Online Comment

Application H16-0089-24
Location CROMWELL HOUSE 65 DOUBLE STREET SPALDING PE11 2AB
Proposal Replace boundary fence with brick wall

Name Historic Environment Officer
Address Lincolnshire County Council Lancaster House 36 Orchard Street LN1 1XX

Sheet Information
Details for Wall

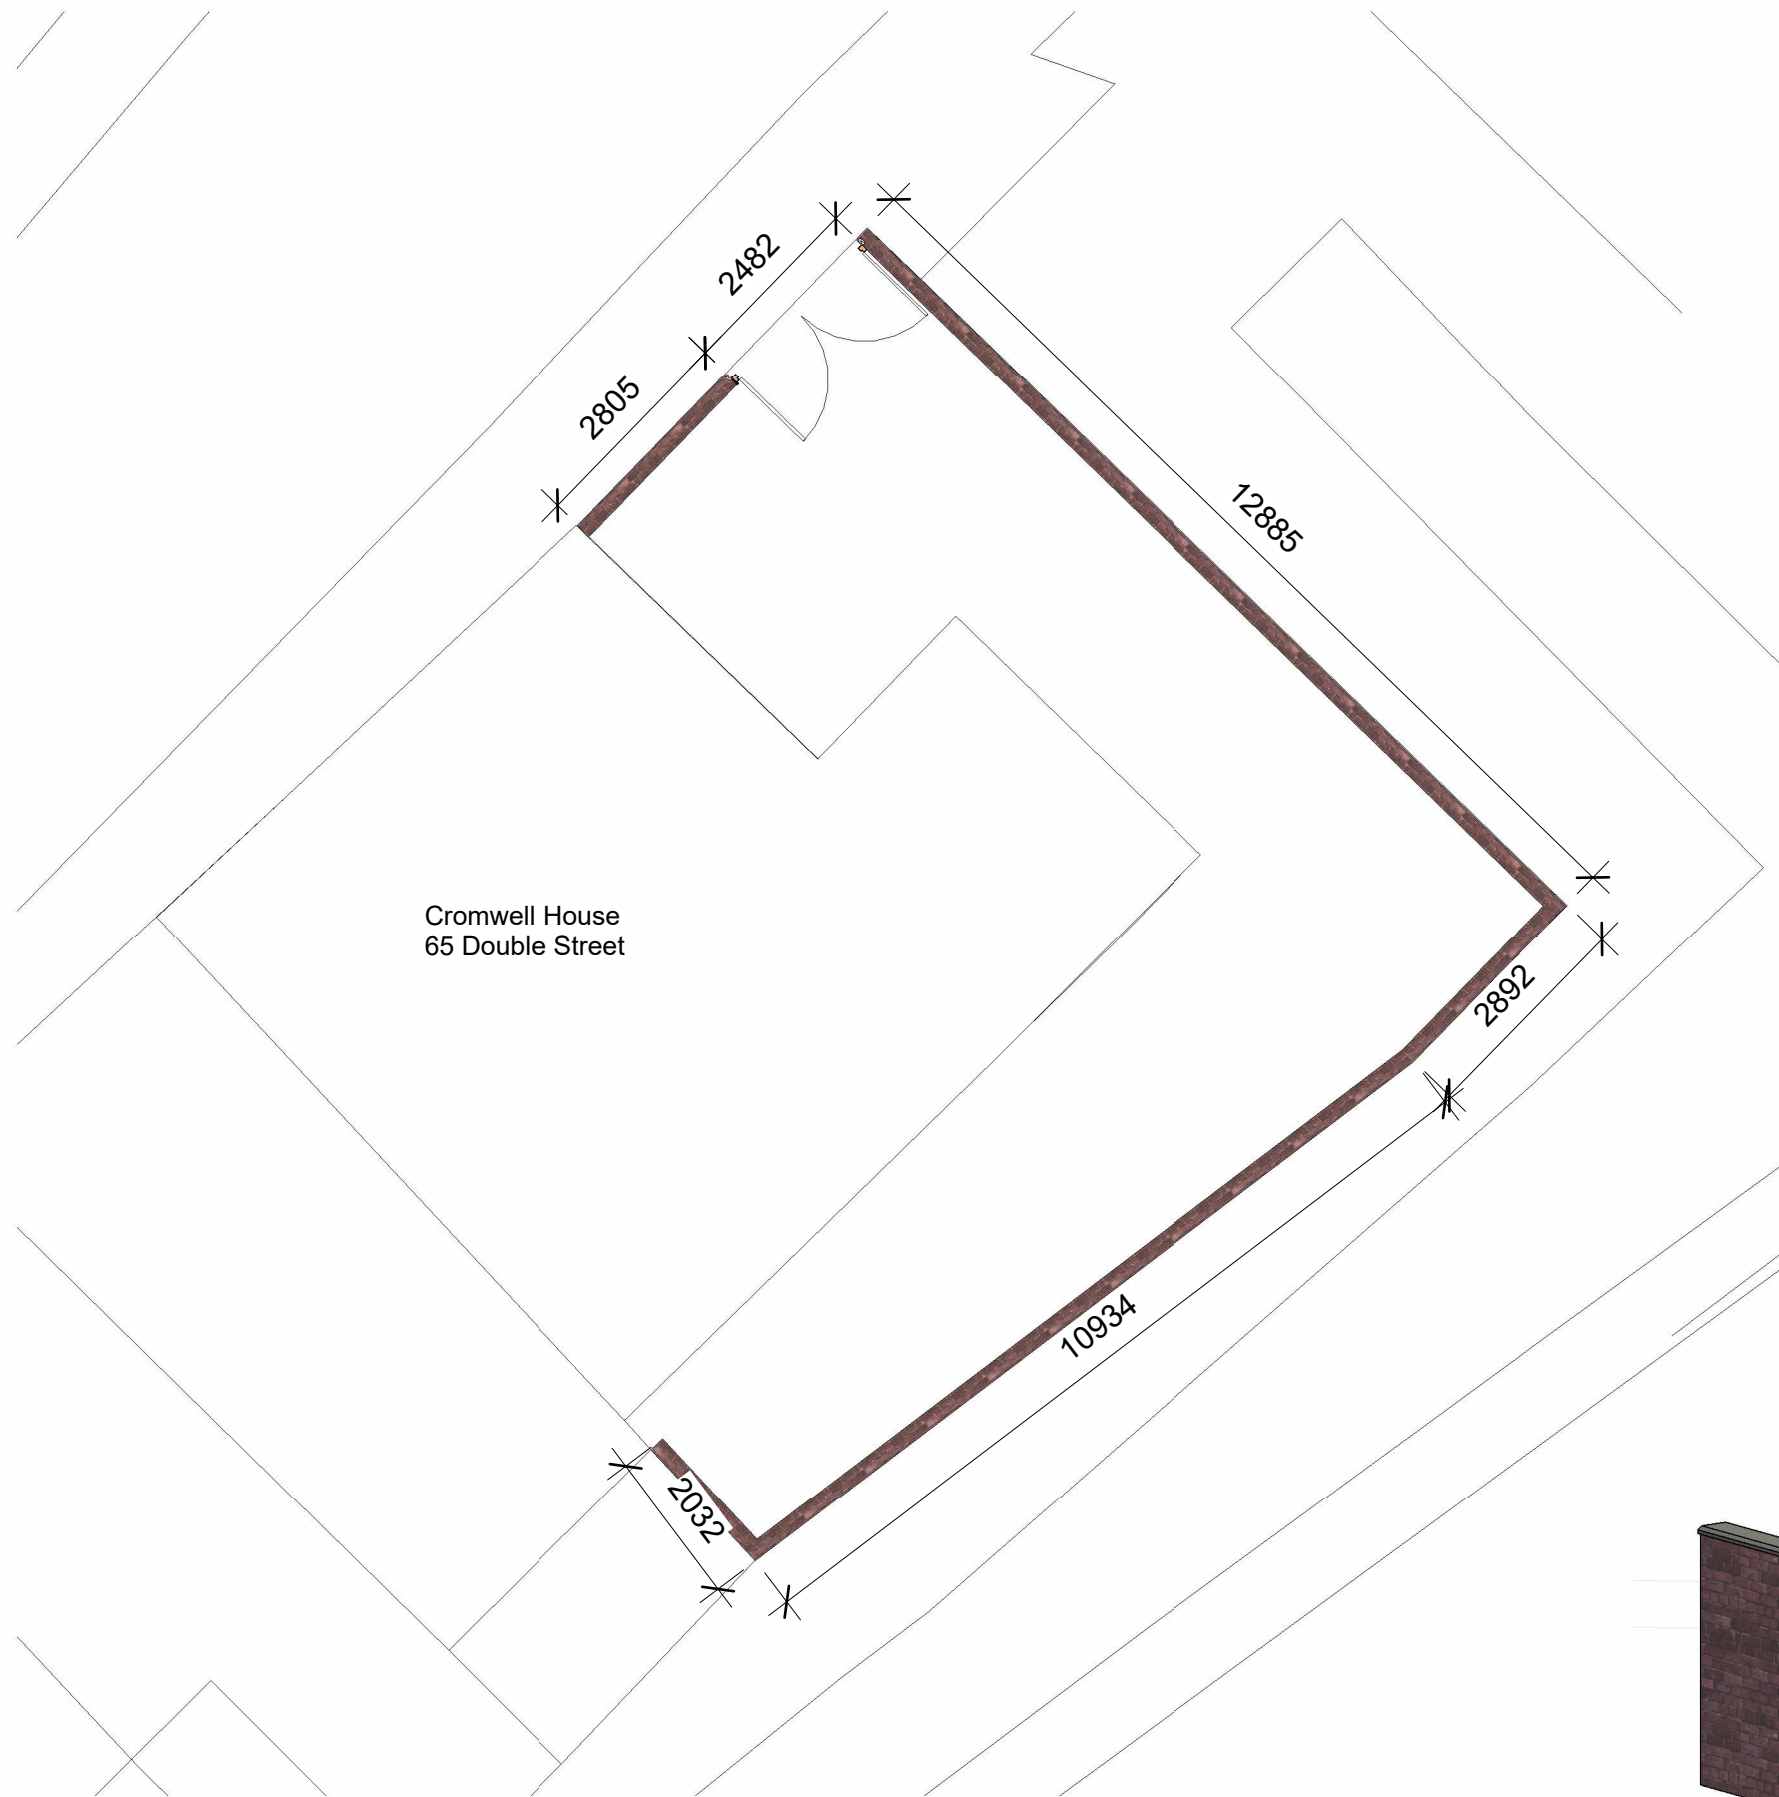
The reason is that the impact of the proposed development is a relatively shallow wall foundation.

The foundation trench for the proposed boundary wall will be excavated through the 19th and 20th century upper deposits with no likely impact upon any significant archaeology. Consequently, no further archaeological input is necessary for this application.
